OXFORDSHIRE COUNTY COUNCIL'S RESPONSE TO CONSULTATION ON THE FOLLOWING DEVELOPMENT PROPOSAL

Application no: 16/00864/REM

Proposal: Reserved Matters Application for 10/01642/OUT - Dorchester Phase 8 (Trident) only. The application represents the provision of 91 residential units of mixed type (dwellings and apartments) and tenure (open market and affordable) with associated gardens, access roads, car parking, landscaping, a local area of play (LAP), utilities and infrastructure.

Location: Dorchester Phase 8 Trident Only Camp Road Upper Heyford

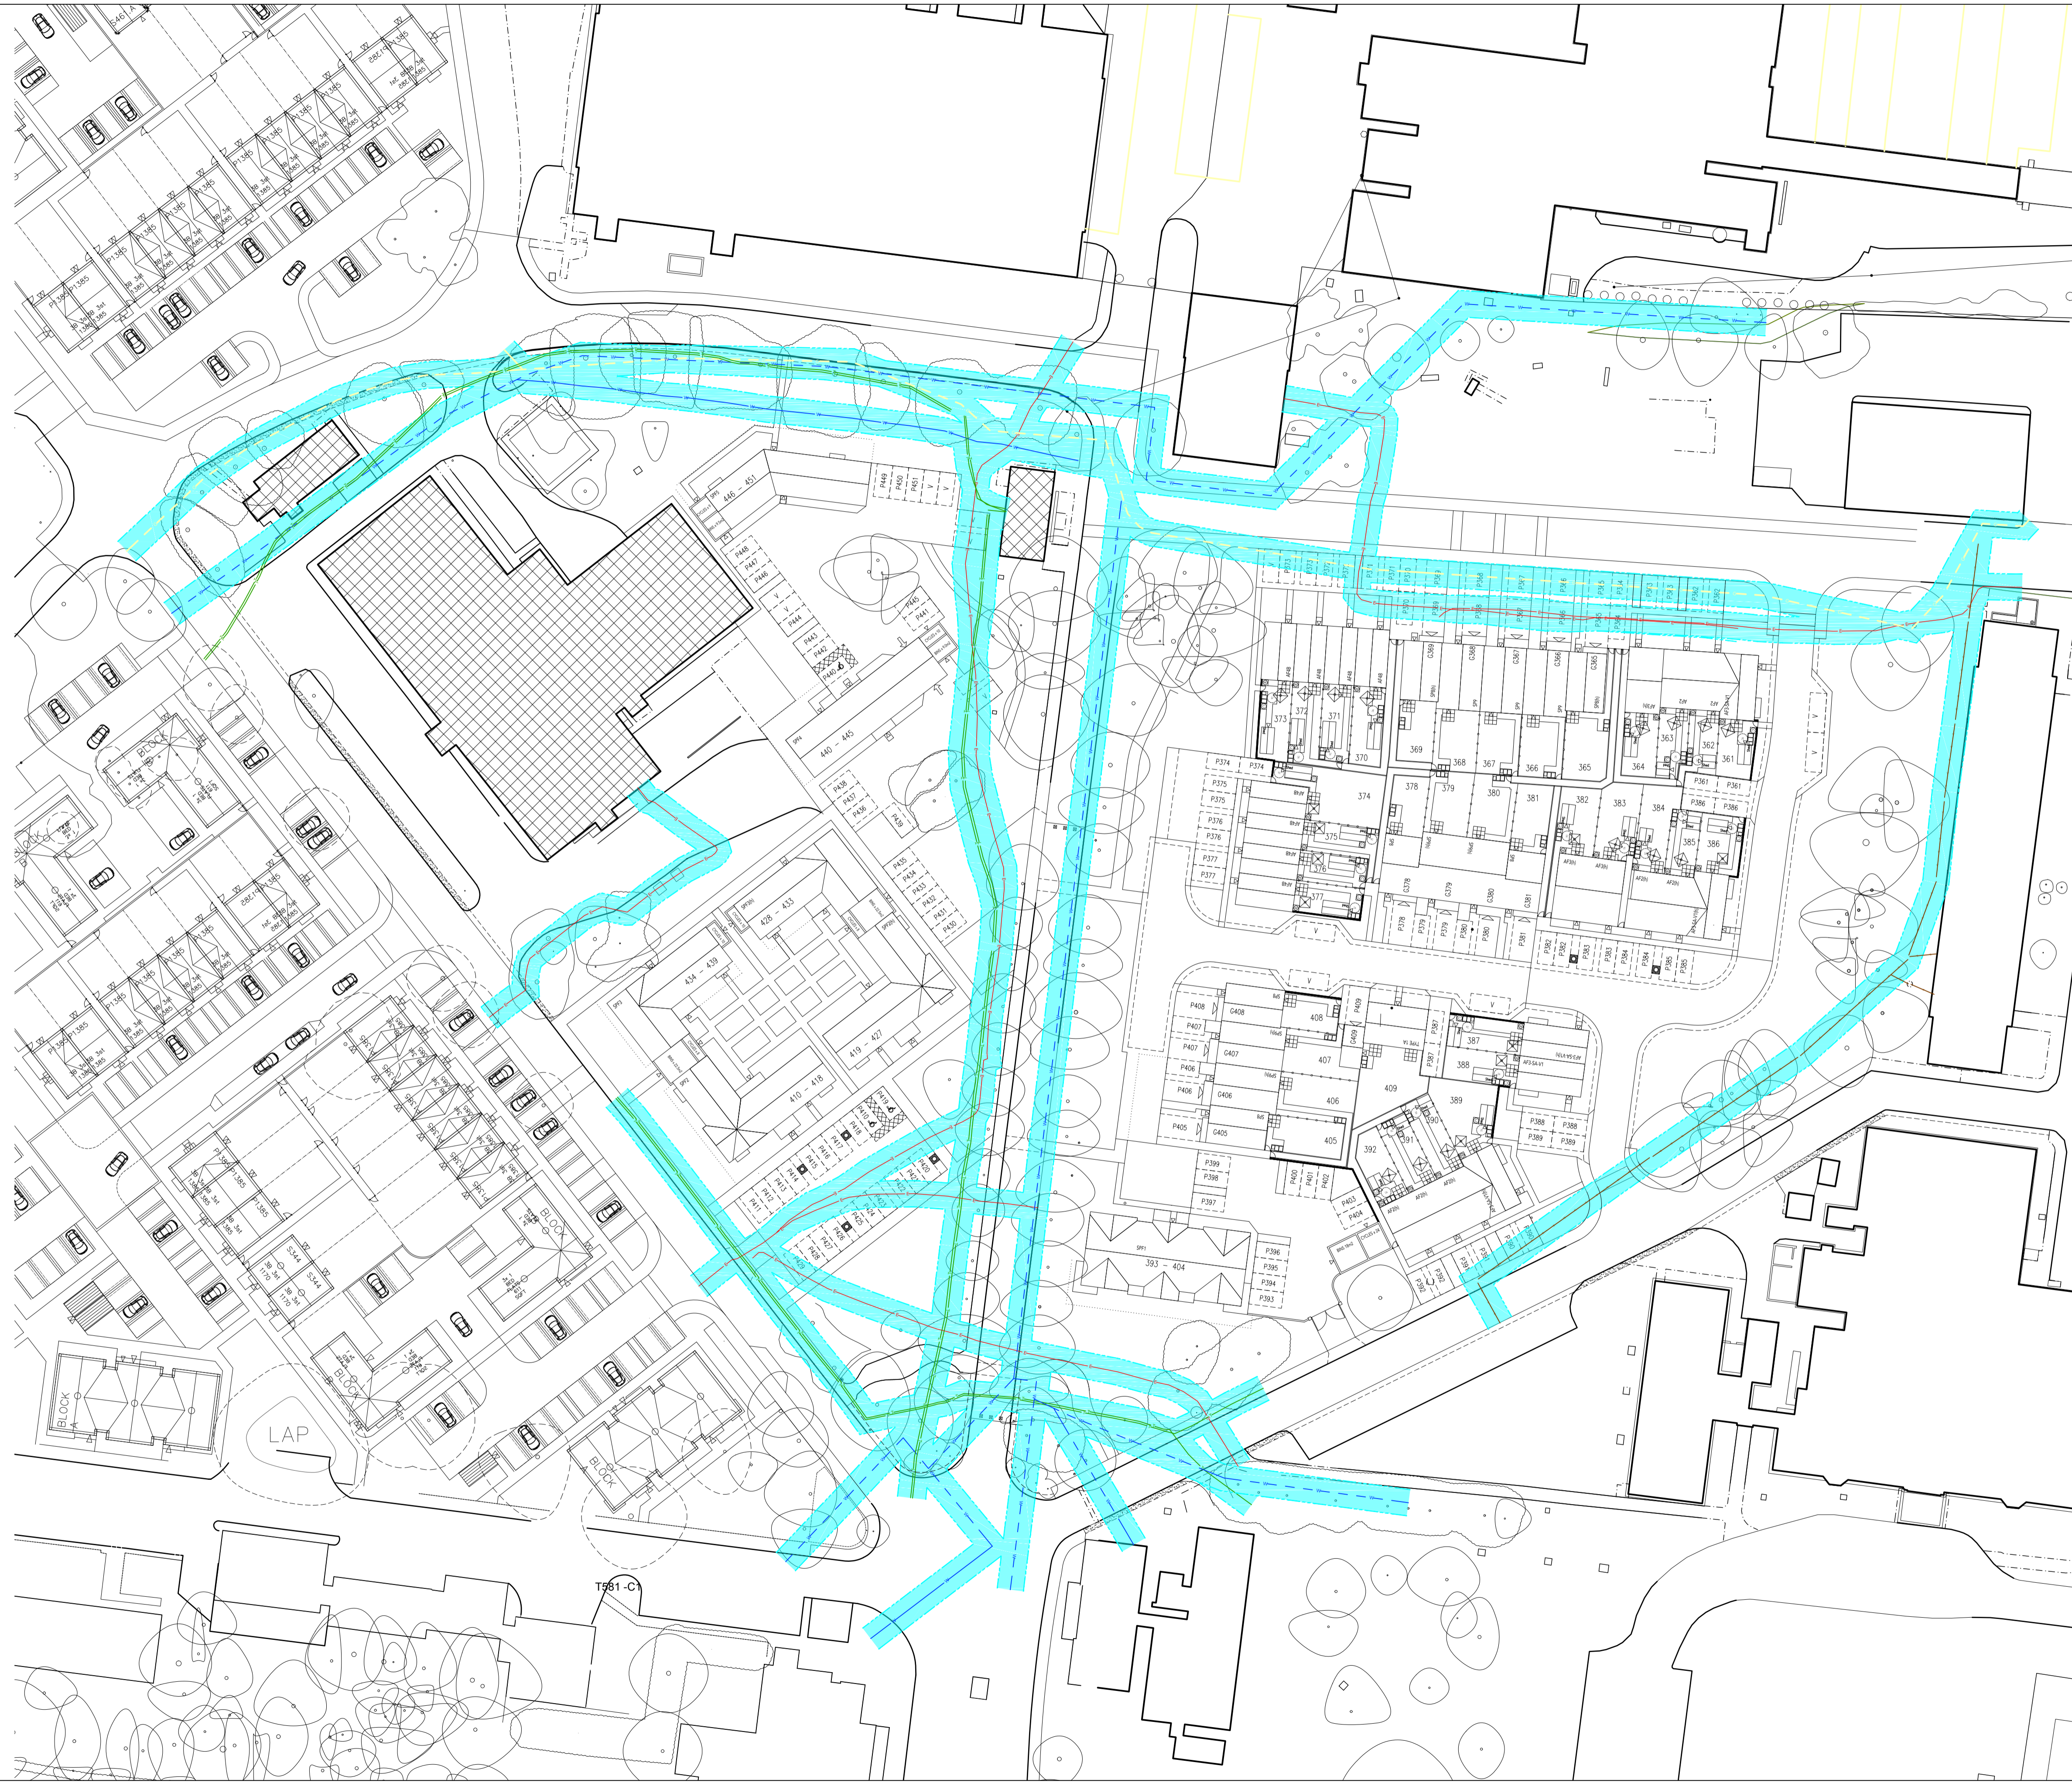
It is not clear what the layout or method of control will be for the Trident junction immediately to the south of the development site. It should be noted that the existing deflections are not ideal for a roundabout. This leads to safety concerns.

The long straight sections of 6m wide carriageway will promote speed, and no traffic calming measures are proposed. Traffic calming will be required for road safety reasons. **Reason for objection.**

The red line site boundary in the North and West of the site only include the carriageway and not the adjacent footways. Without pedestrian footways the roads that form part of this

planning application not acceptable. These roads will need to be lit, and therefore street lighting columns will need to be positioned within adoptable areas. **Reason for objection.**

The junction on the North West corner of the site is only partially within the red line. It is not therefore possible to comment on the acceptability of this junction layout. **Reason for objection.**

The footway links terminate before the Trident junction with no continuity within the red line. **Reason for objection.**

The Western footway on the centre road of the trident terminates to the North just before a 90 degree bend leading to safety concerns.
